## MMC: FW: Shaws TCP (CMP)

**Mike Tremblay** <mtremblay@portlandmaine.gov>  
To: Helen Donaldson <hcd@portlandmaine.gov>  
Cc: Thomas Errico <thomas.errico@tylin.com>

Fri, Apr 26, 2019 at 9:41 AM

FIGURE  
**3C**

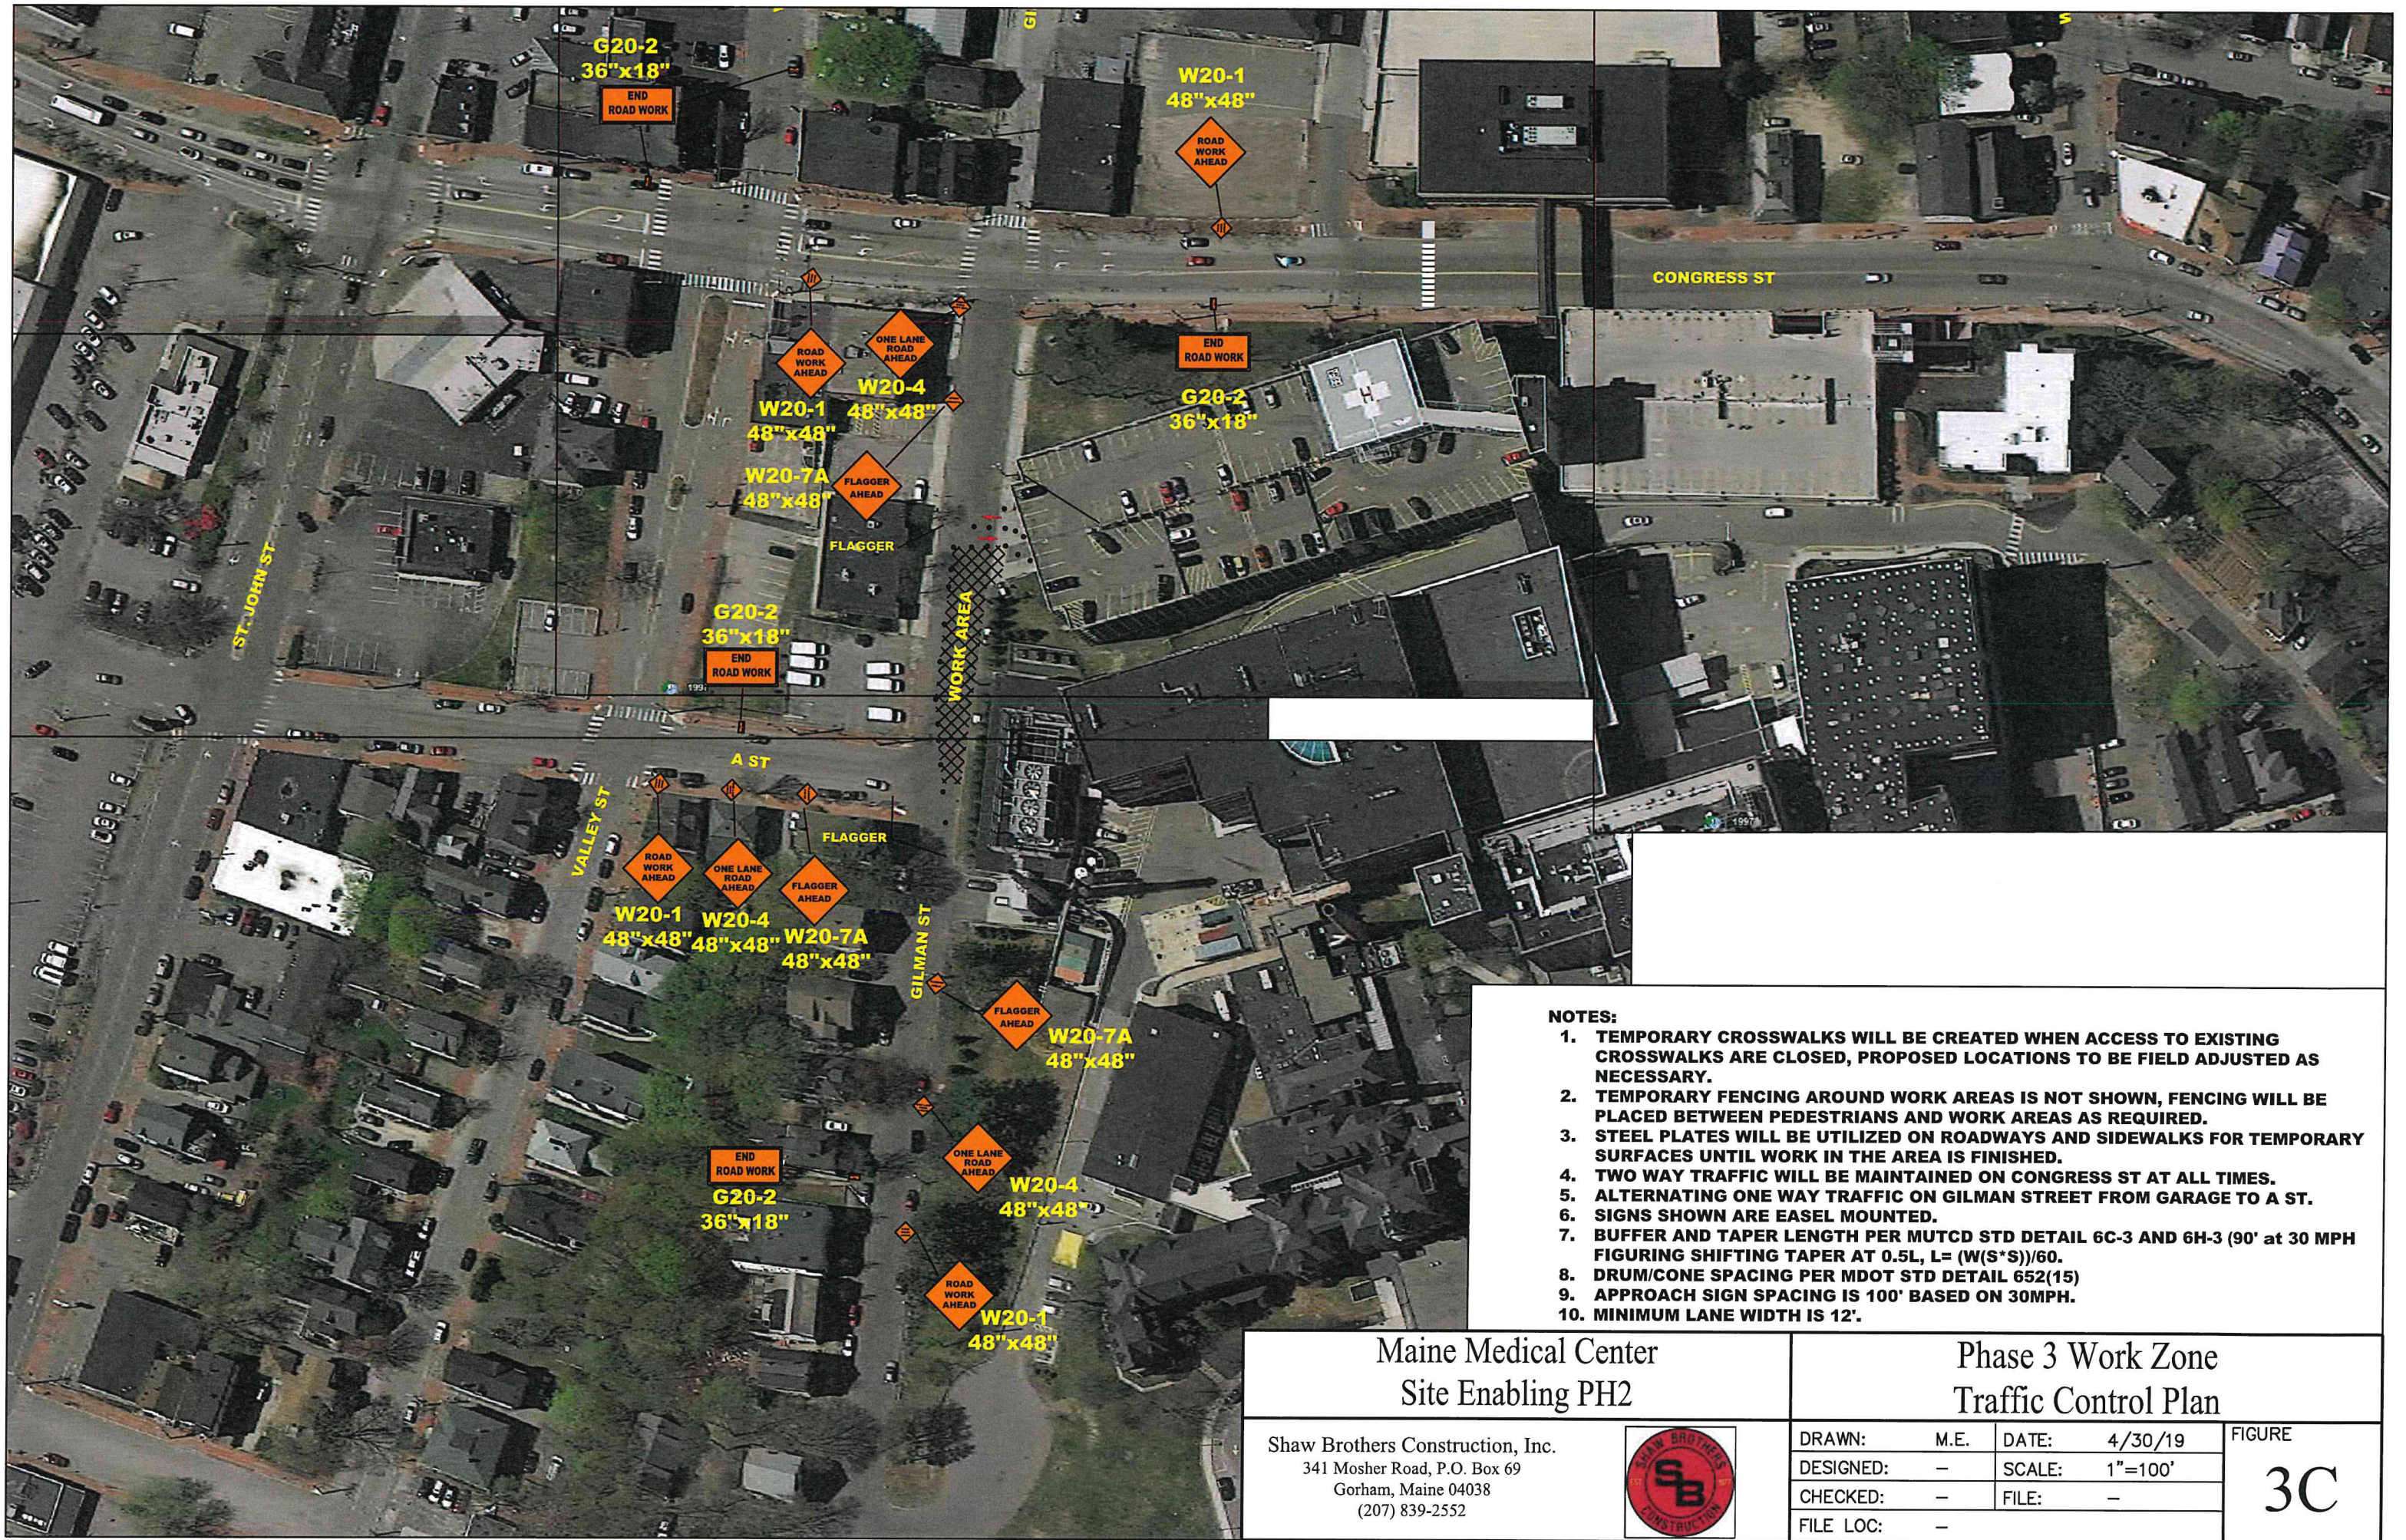
- The "No On-street Parking signs" - is this a typical/standard sign? Or would this be handled via temporary signs installed by DPW? I just don't think I've ever seen this sign before.
- Sheet 1C: The EB pedestrian detour needs a left-facing arrow; currently a right-facing arrow is shown.
- Sheet 2A and 2A-1: Need pedestrian detour if the crosswalk across Gilman Street is closed.
- Sheet 2C: the EB pedestrian detour needs a "cross here" sign, or peds may walk down Gilman only to find that sidewalk is closed too
- Sheet 3A: Need a pedestrian detour for EB pedestrians
- Sheet 3B and 3C: Sidewalk on Gilman Street appears to be partially closed. Need a pedestrian detour.
